A303 Sparkford to Ilchester Dualling Project

Phil Gamble – registration identification number 20015057

Submission to the Open Floor Hearing at the SSDC Offices on 12th December 2018.

WORK NO.17 DOWNHEAD LANE

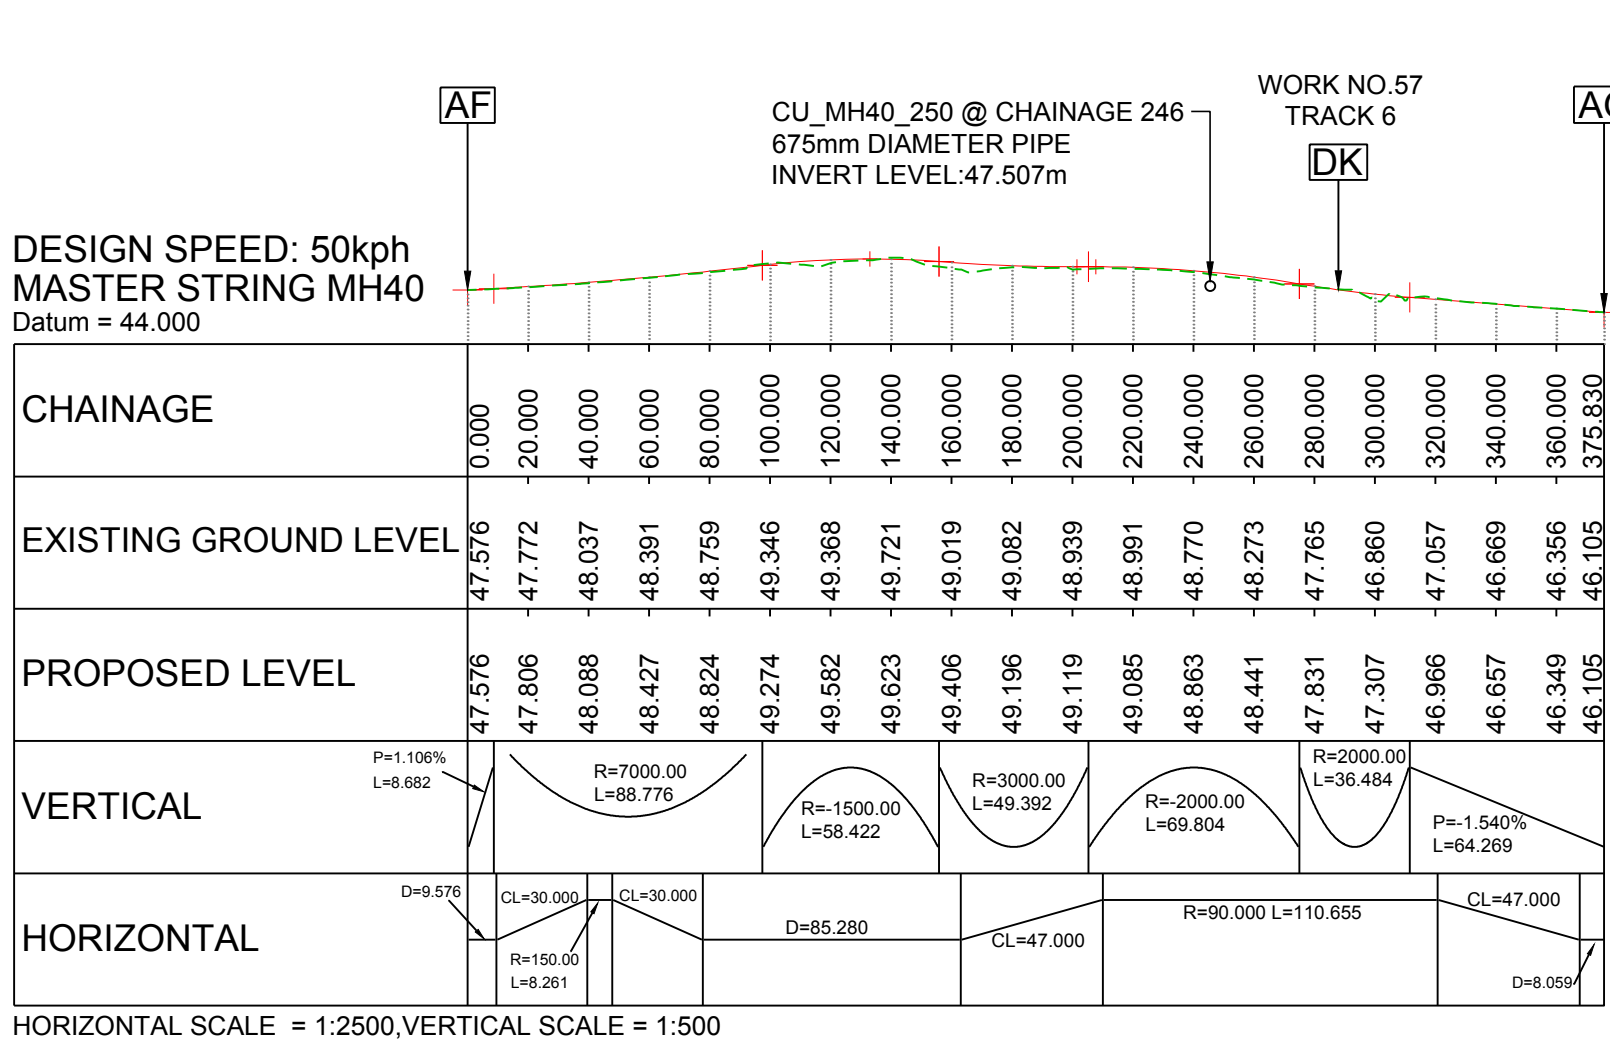
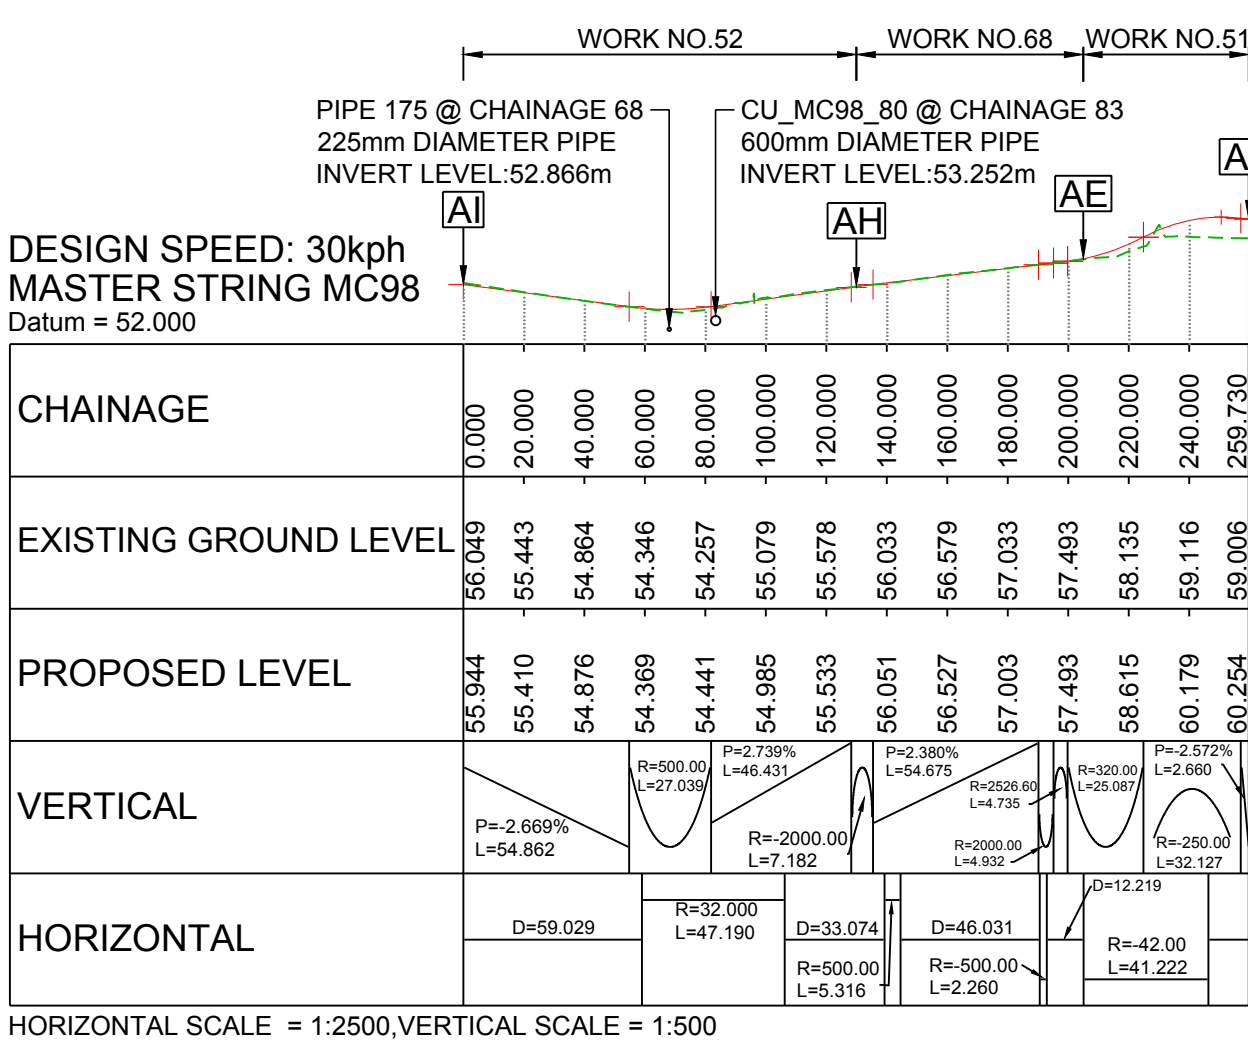
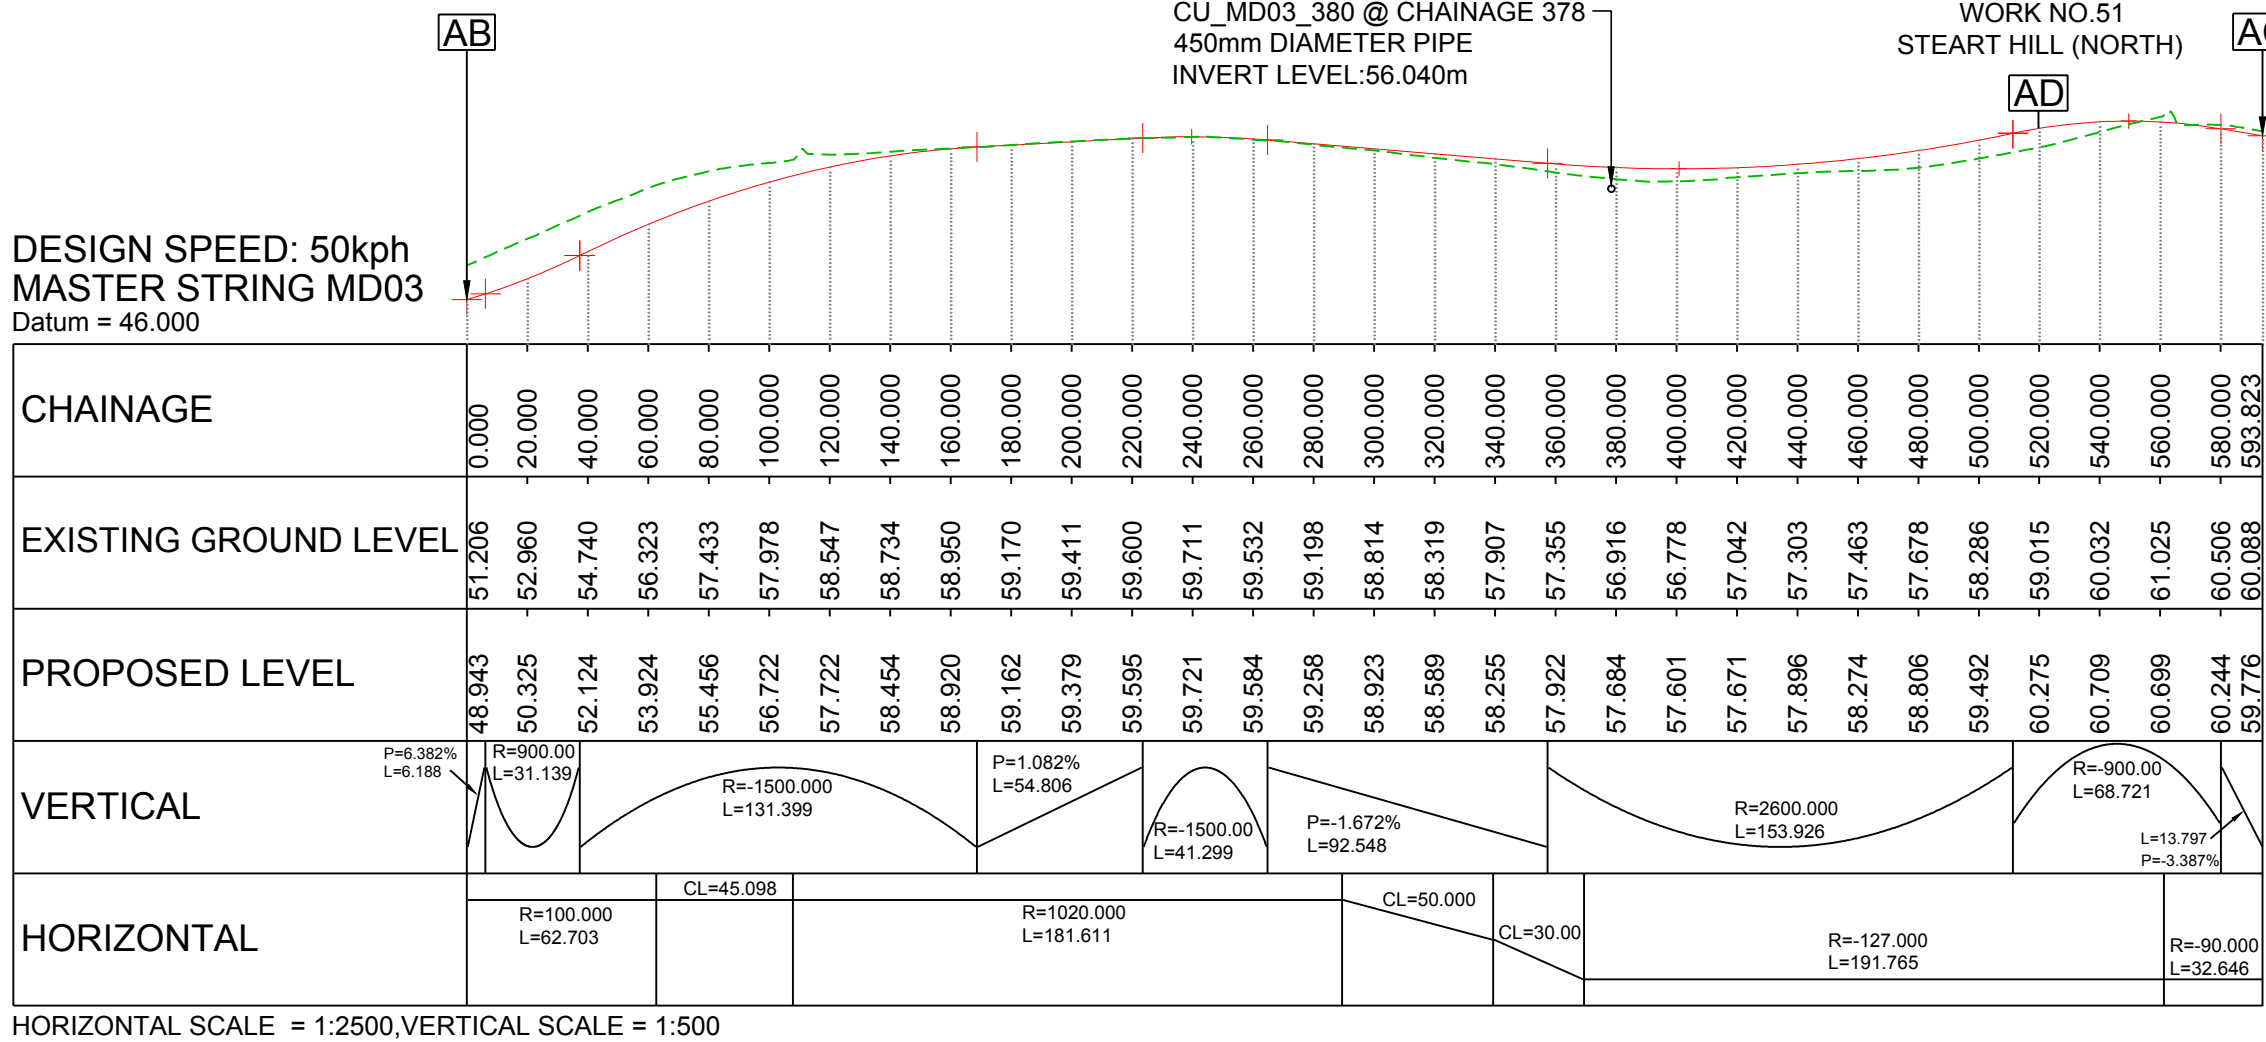
- 1. My first challenge is the need for a mid-section east-bound junction at Downhead. This junction does not connect into the National A-road trunk network.**

The Downhead junction only provides local access but I recognise it would provide easy access for two large agricultural enterprises situated north of the current A303. In a recent article ([published in the Times "Tractor ban on A-roads puts farmers in a jam" page 18 Saturday 27th October 2018](#)) Jim O'Sullivan, chief executive of Highways England, confirmed their continuing commitment to convert a small number of dual carriageways into motorway standard expressways starting with the A14(M) between Cambridge and Huntingdon.

I believe to provide this new junction is questionable and certainly not a good use of public money to provide a junction which becomes unusable by a major user.

With regard to the safety issue. In Highways England's own words from their technical report "Fewer junction means improved safety - reduces junction hopping and carriageway weaving". With less than 6kms between junctions at Podimore and Hazelgrove the safe use of the proposed dual-carriageway could be improved by removing the Downhead junction.

Without the Downhead junction it would be possible to upgrade the A303 from Mere to Podimore and beyond to Expressway standard without any impact on local connectivity. Over this section there are existing local roads to maintain local access, with no further actions or expense necessary, assuming the southern link road is maintained.

In addition provision of the eastbound junction at Downhead would make it easier and in fact encourage commuters to the south east, Sherborne and beyond, to use West Camel village as a cut through.
